Application for a non-material amendment following a grant of planning permission,
 Town and Country Planning Act 1990

FP/20/20/NMA

Unit:		House number:	40	House suffix:	
House name:					
Address 1:	LEVERTON AVENUE				
Address 2:	FELDHAM				
Address 3:					
Town:	BOGNOR REGS				
County:					
Postcode (optional):	PO22 7RA				
Description of location or a grid reference. (must be completed if postcode is not known):					
Easting:		Northing:			
Description:

TWO STOREY REAR EXTENSION - +
GARAGE TO SIDE

MR & MRS D. CUMMINGS			
PROPOSED DOUBLE STOREY EXTENSION AT 40 LEVERTON AVE FELPHAM			
JDM	FEB-19	1:5000A1	JDM
001

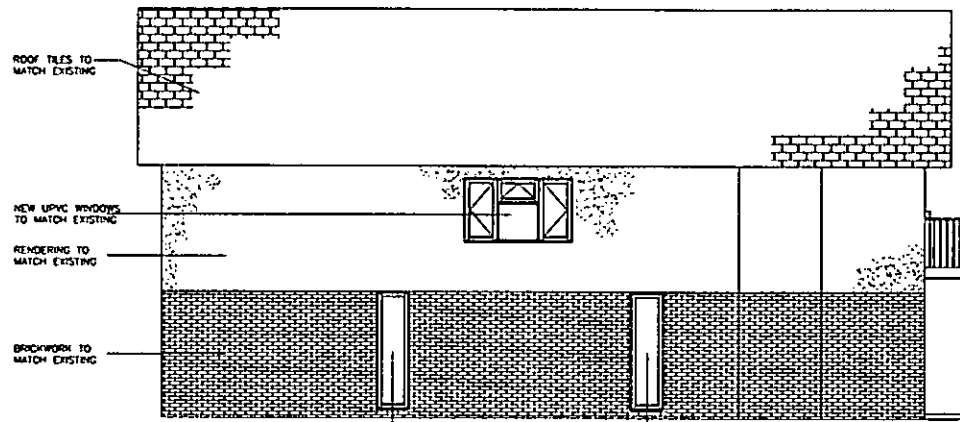
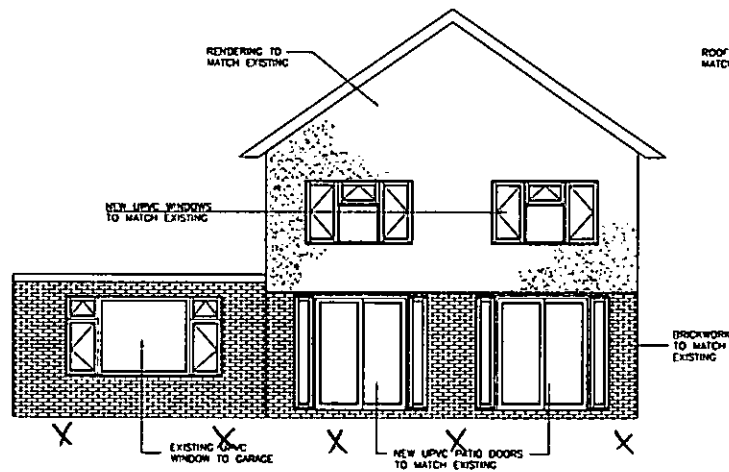
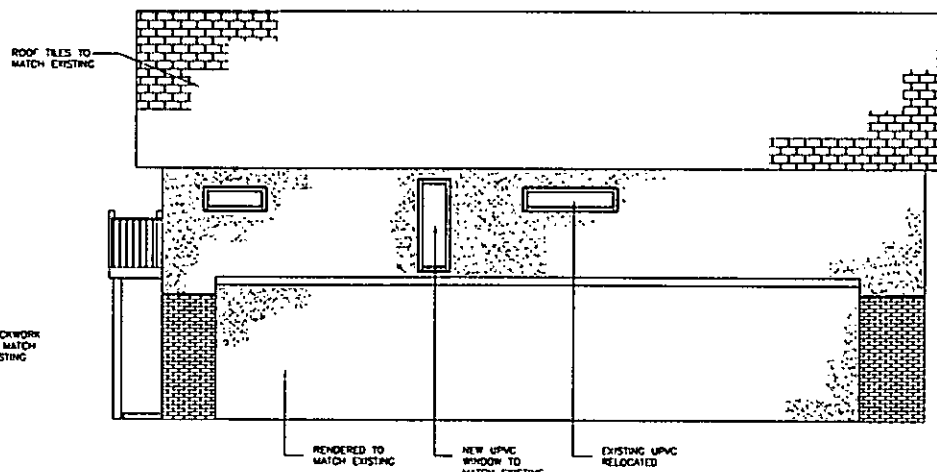
MATERIAL CHANGE FROM FACE BRICK TO BLOCK AND RENDER.

DRAWING MARKED WITH AN X INDICATE THE
ORIGINAL AREA PROPOSED TO BE NOW RENDERED.
